THE ASTOR

**Objection to SSDA 10464 50-52 Phillip Street
New Hotel/Residential Building Stage 1 Concept DA**

Schedule 1 – Objection to SSD 10464 50-52 Phillip Street New Hotel/Residential Building Stage 1 Concept DA by the Astor Board - Key issues/impacts and preferred action

### Proposed Podium

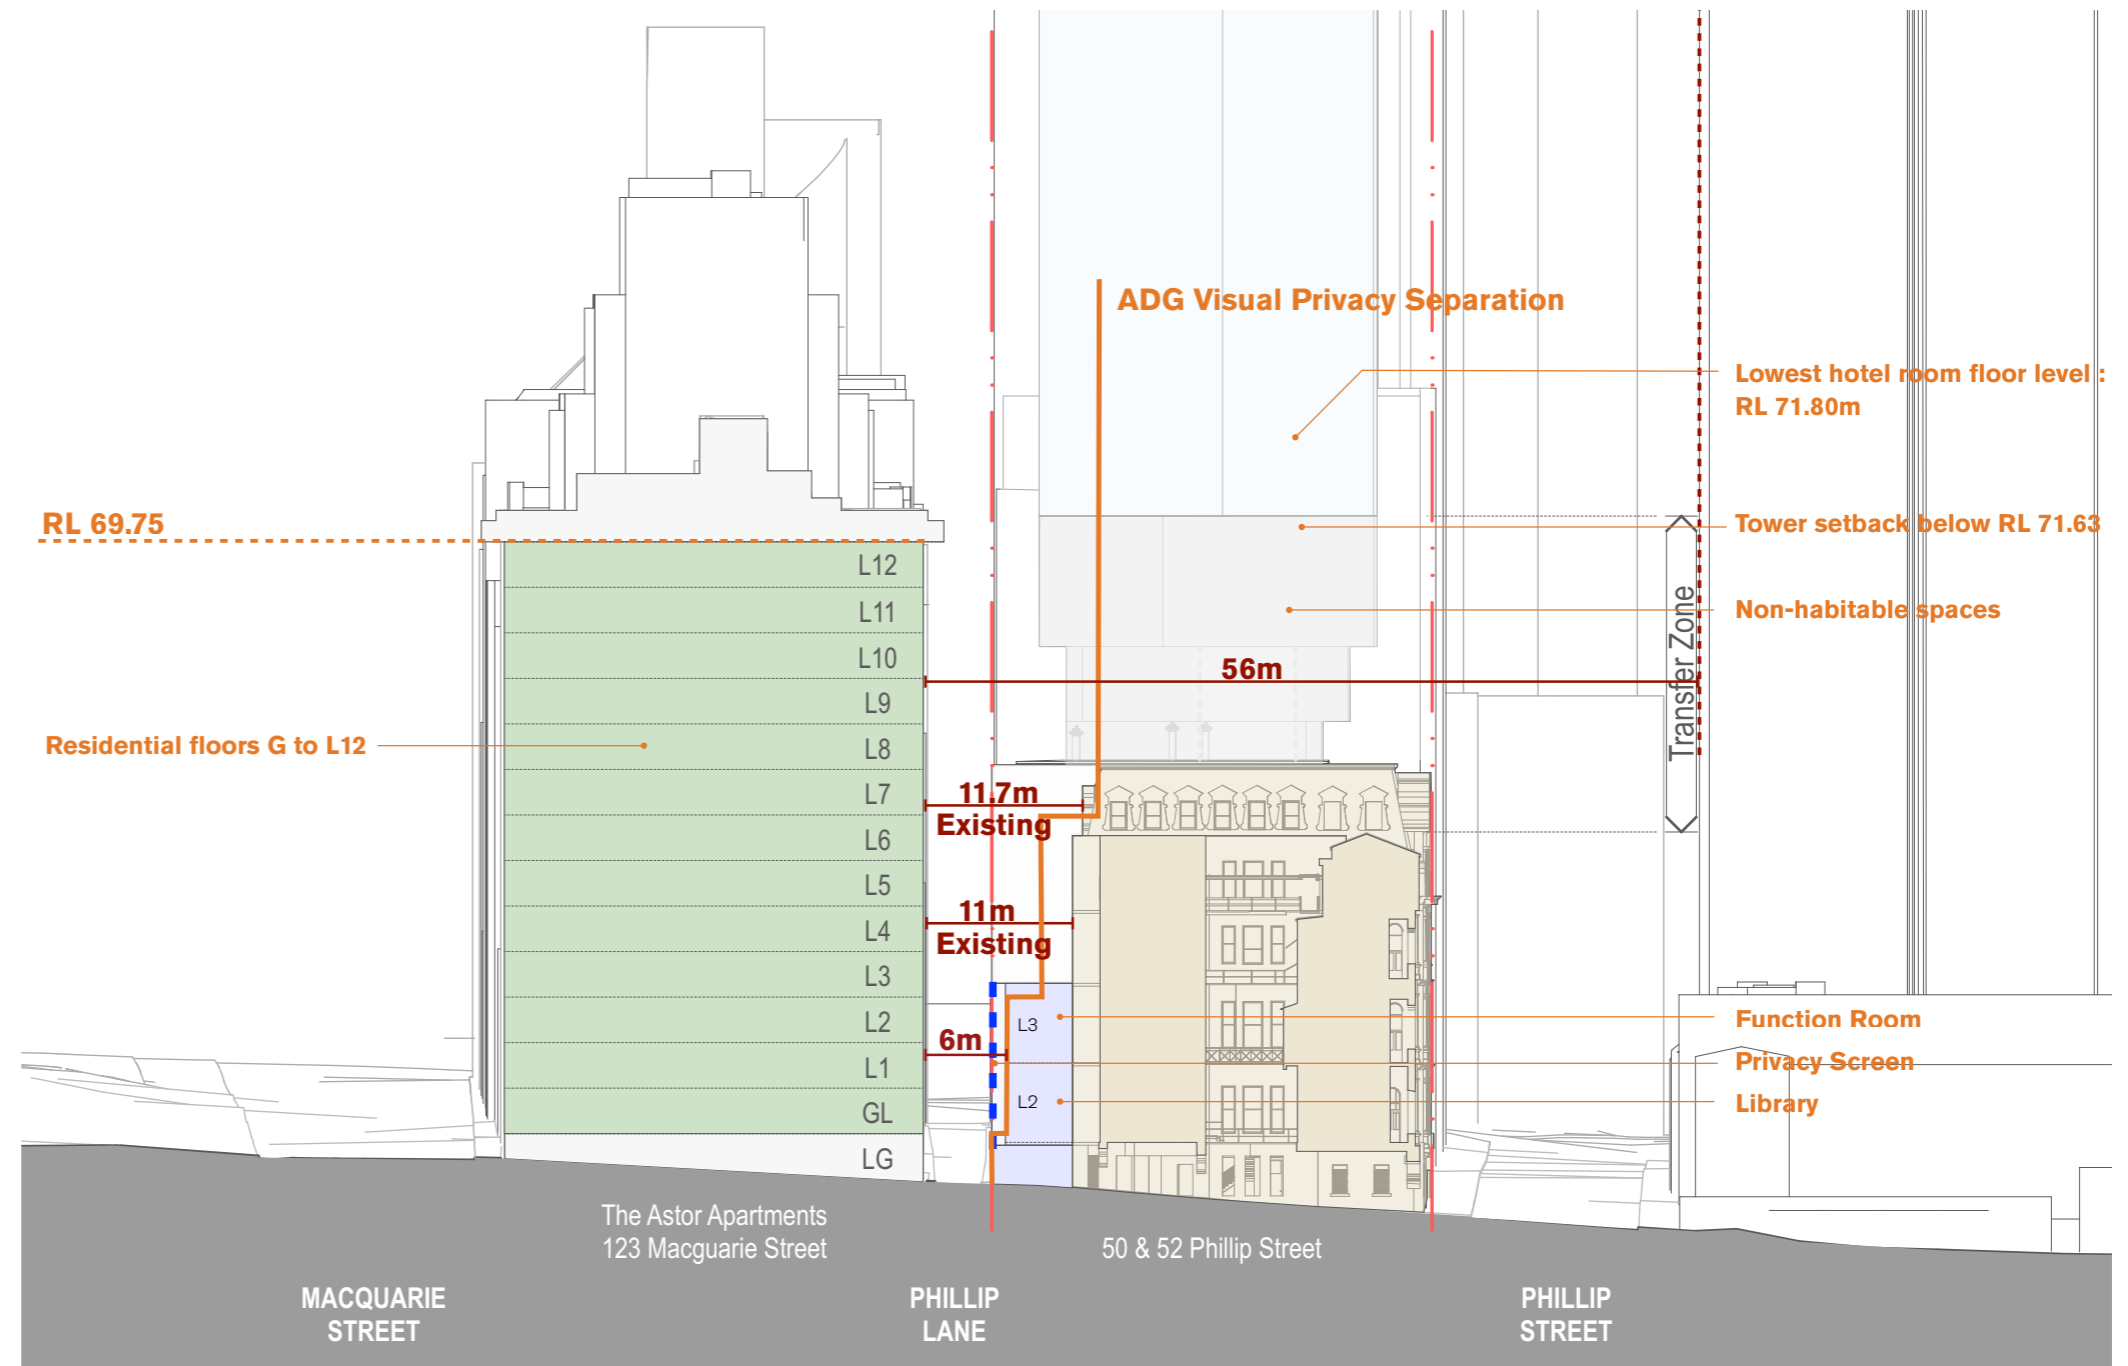
14	Inadequate separation between the proposed lower podium infill on Phillip Lane and the residential uses of the Astor	<p>The separation distance between the existing residential apartments of the Astor at the lower levels and the proposed new podium envelope fails to achieve the 12m required by the NSW Apartment Design Guide. Despite the indicative design, in fact the Stage 1 application does not provide certainty regarding the use of these spaces. Accordingly the assessment in the EIS regarding visual privacy is fundamentally flawed and the envelope should not include any new building massing on Phillip Lane unless it is set</p>	<p>We request the Department not to approve the proposal unless it achieves at least 12m separation from windows of the Astor up to level 4, 18m from levels 5-9 and 24m above that</p>

back 12m from the Astor's windows. A design which at Stage 1 has separations less than those the ADG identifies as good design practice and which is already resorting to screening to achieve privacy instead of achieving adequate separation is indicative of poor design and should not be approved.	for any new building forms.
15	Privacy impacts on the rooftop communal open space of the Astor	The EIS has not considered the potential for privacy impacts between the proposed tower and the rooftop communal open space of the Astor. It notes that the first hotel floor is at RL71.80m and the last residential floor of the Astor is at RL69.75m. In other words, the rooftop of the Astor and the hotel's lowest rooms are essentially on the same level. The downward sloping facade of the tower's lower forms will also inappropriately focus views from the space behind towards the Astor rooftop exacerbating privacy concerns despite the separation distance. Astor residents and visitors should be able to use the existing rooftop space without feeling scrutinised.	We request the Department not approve the application unless the design is amended to provide greater vertical separation between the Astor rooftop communal open space and to not include any habitable rooms with downward sloping glazing directed towards the Astor rooftop.
